## WD Rolling Thunder Core & Shell Special Use

PCD File  
AL245

# Letter of Intent

SITE PLAN/COVER SHEET

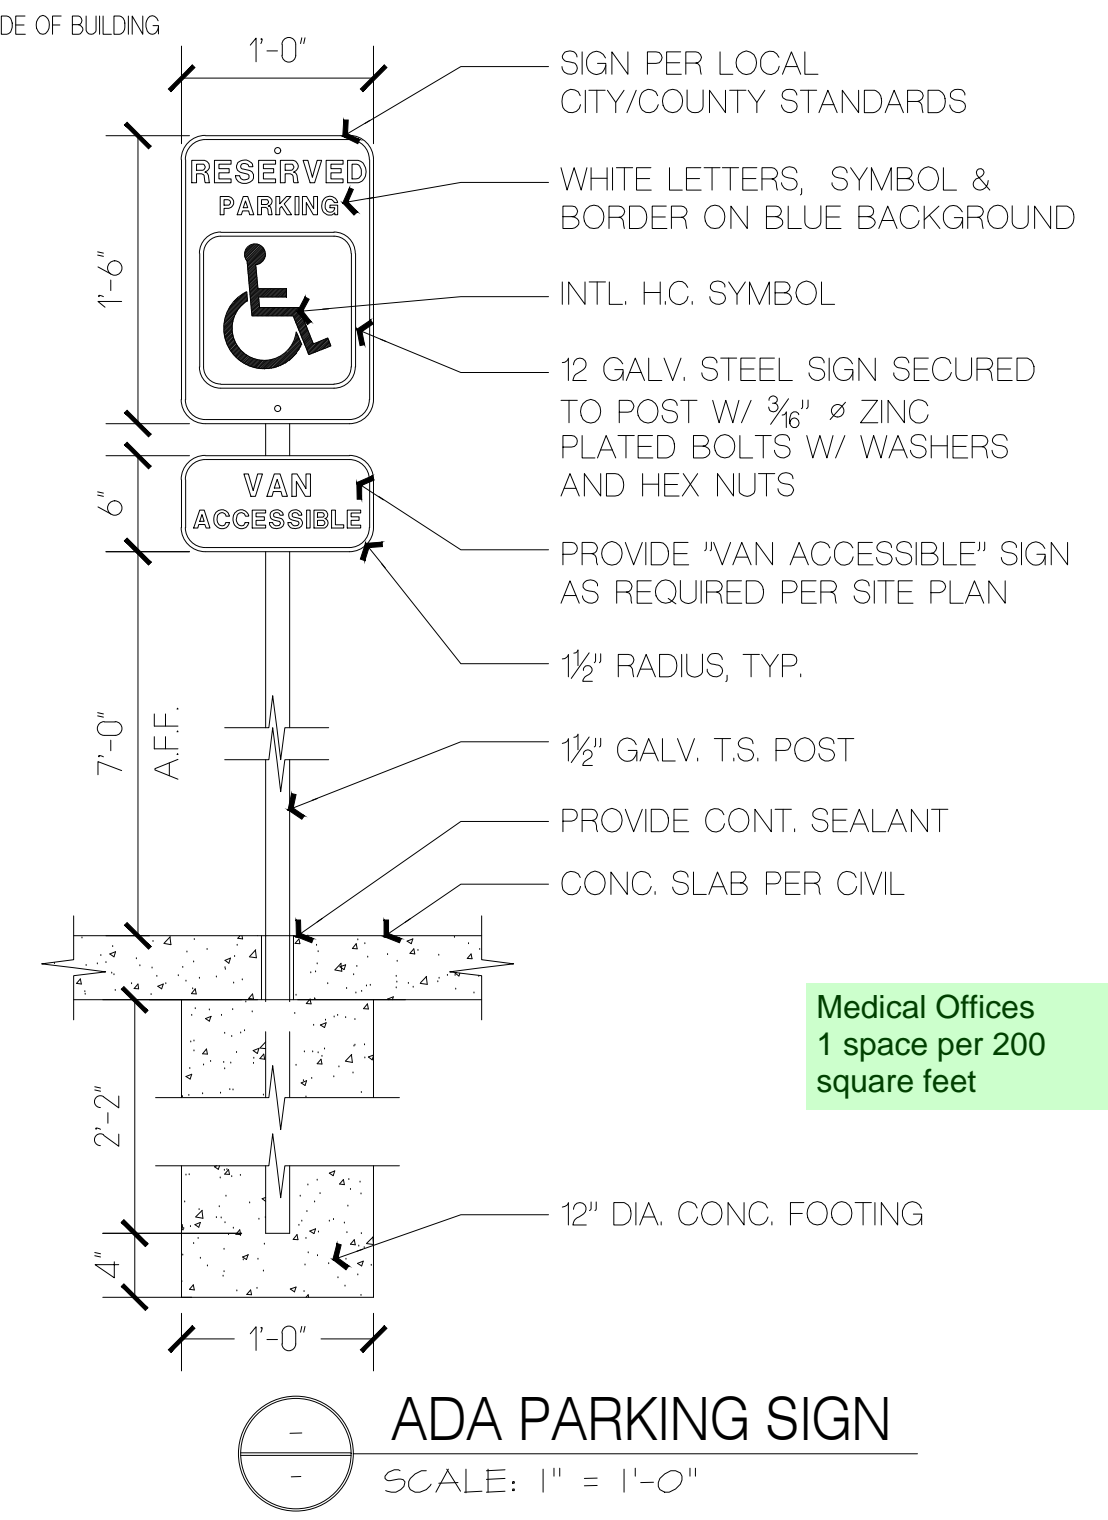
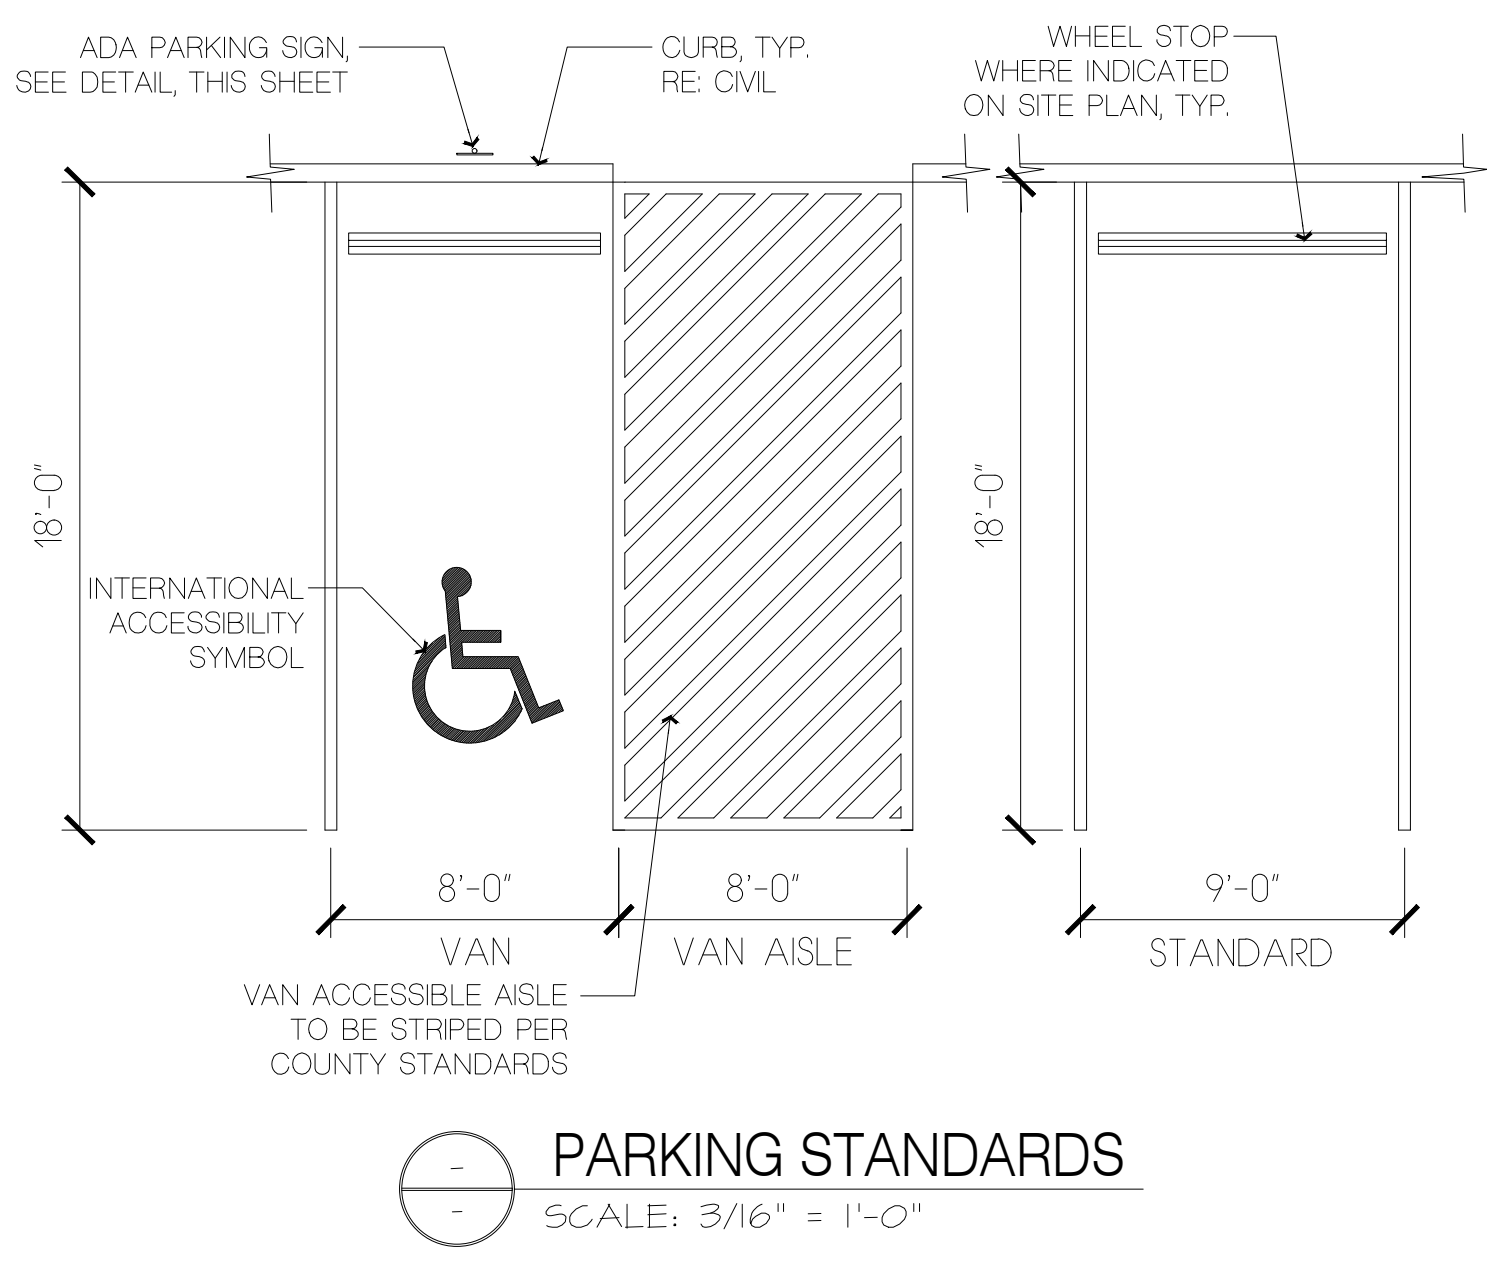
Please review the parking calculations on the site plan.

Medical Offices  
1 space per 200 square feet
